**WELWYN HATFIELD COUNCIL – DEVELOPMENT CONTROL**  
**DELEGATED REPORT**

<b>APPLICATION No:</b>	S6/2009/0994/AD & S6/2009/0995/LB
------------------------	-----------------------------------

The previous company (Next Generation) has recently merged with David Lloyd and is going through the process of re-branding. At the time of the site visit the proposed signage had been erected. The signage is of a similar appearance and has similar siting to the previous signage. The signs state 'DAVID LLOYD CLUBS' and comprise individual, internally illuminated characters.

Sign A - New Logo Sign
Individual Aluminium Letters

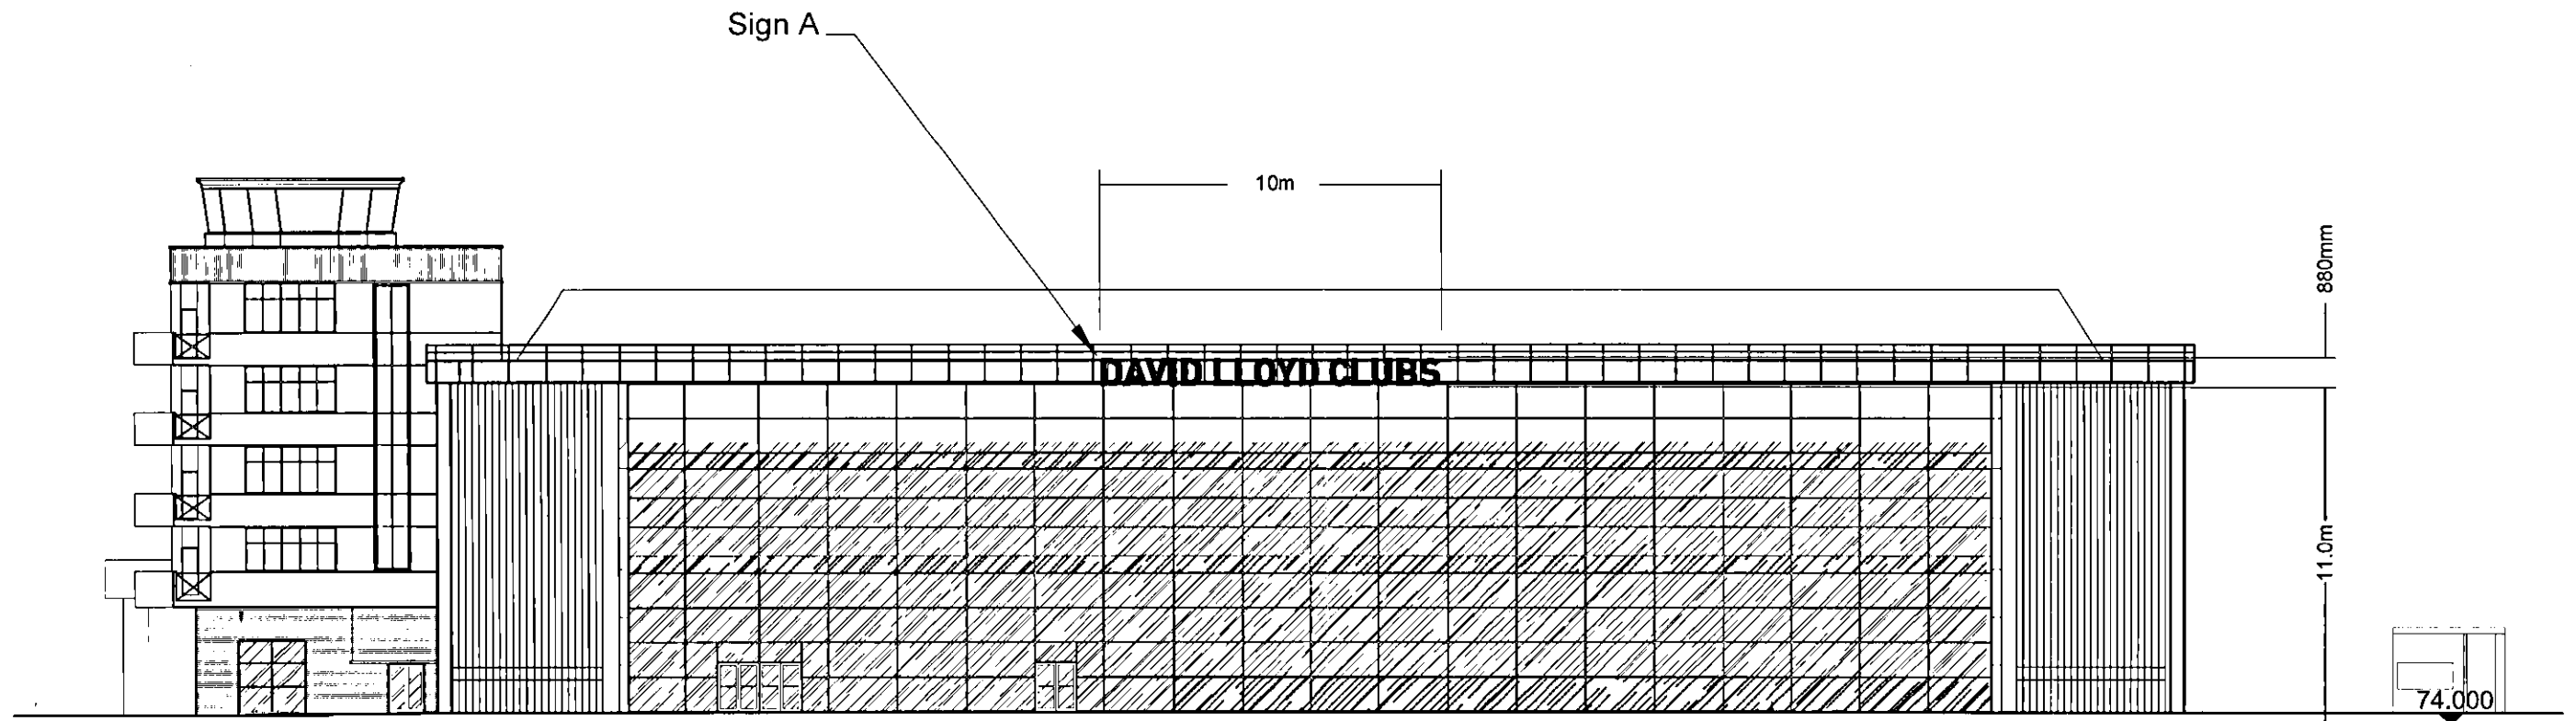
1. The proposed signage would involve the replacement of previously approved signage to the northern and southern elevations of the main building. It has been noted that these alterations would have a similar appearance to the previous

approvals and that the development would have less characters and therefore span less area than the previous signage.

As the signage had been erected at the time of the site visit, it could be fully assessed. Photographs of the previous signage allow a direct comparison to be made. Although different, there is no further harm or impact. The addition of the club's new name has little effect on the main building's character and appearance and is a reasonable measure to allow the building to be easily identified. The main building is very tall and dominant and the positioning of the signage is appropriate.
